**Proposed amendment of condition 2 of planning permission A/177/19/PL
to make minor amendments to the approved plans at
The Vinery, Arundel Road, Poling BN18 9PY**

1. Planning permission was granted by Arun DC on 16 April 2020 for a *'New building for storage or distribution, light industrial & office (Class B1/B8) & associated parking.'*

scale @ A1:	1 : 100	client:	Tributes
date:	Nov 2019	project:	Plot A The Vinery, Arundel Road Poing, BN18 9PY
drawn:	AJC	drawing:	Proposed Elevations Sheet 1
checked:	dp	status:	PLANNING APPLICATION

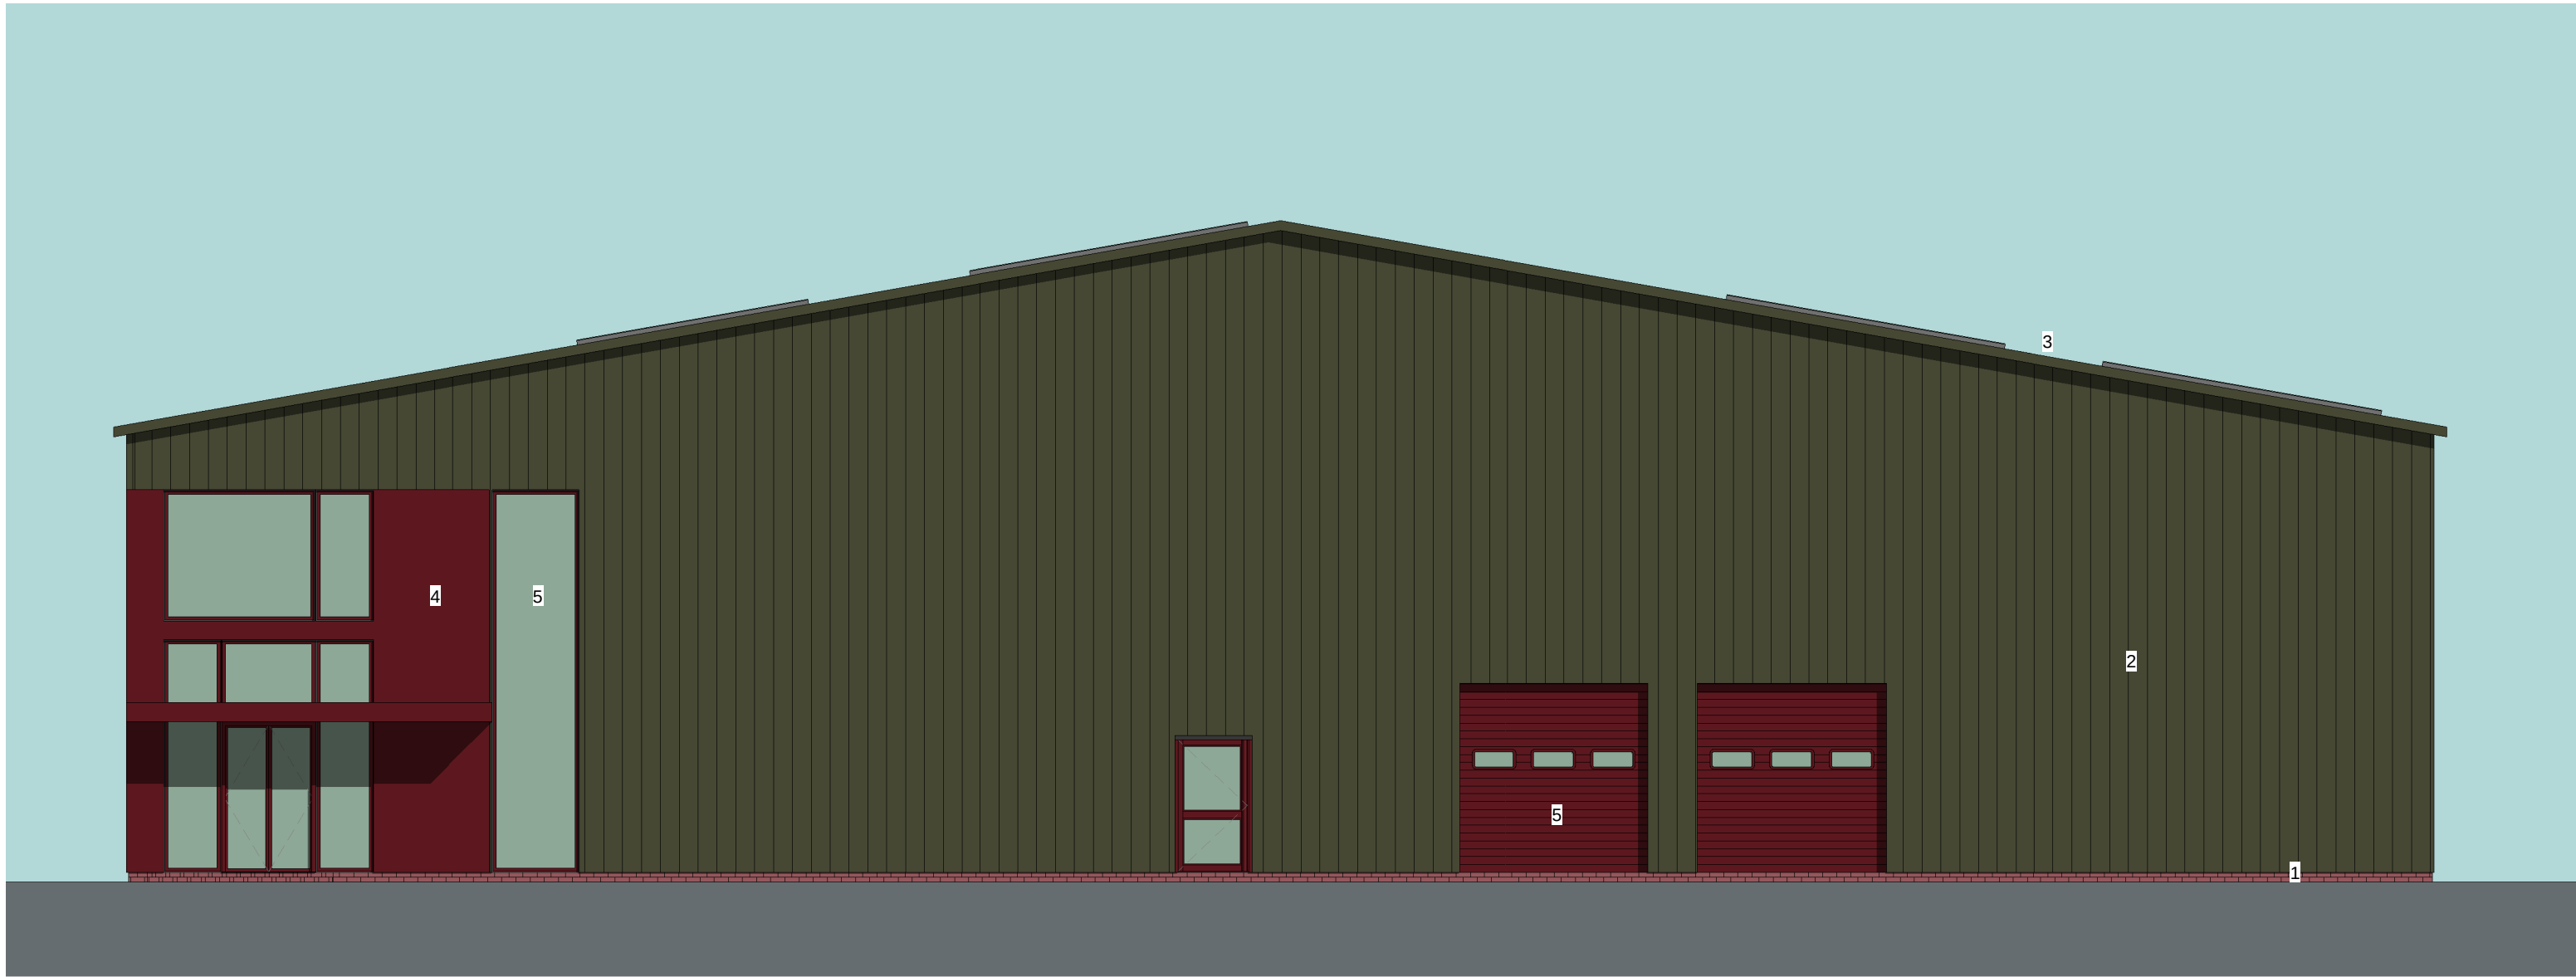
1. The building has been moved 1m to the east to provide a little more space for the existing trees on the boundary.
2. The overall length of the building has been reduced by 3m to ensure that the existing temporary tunnel buildings on the site can be retained while construction works on the new building go on.
3. To retain the floorspace of the building it has been widened by approximately 3m. The overall floorspace has therefore increased from 1663 m² to 1674 m².
4. The car parking has been rearranged at the eastern side of the building and now includes the spaces previously shown to the south of the building. The result is additional amenity space to the south of the building.
5. The south and east elevations have been simplified.
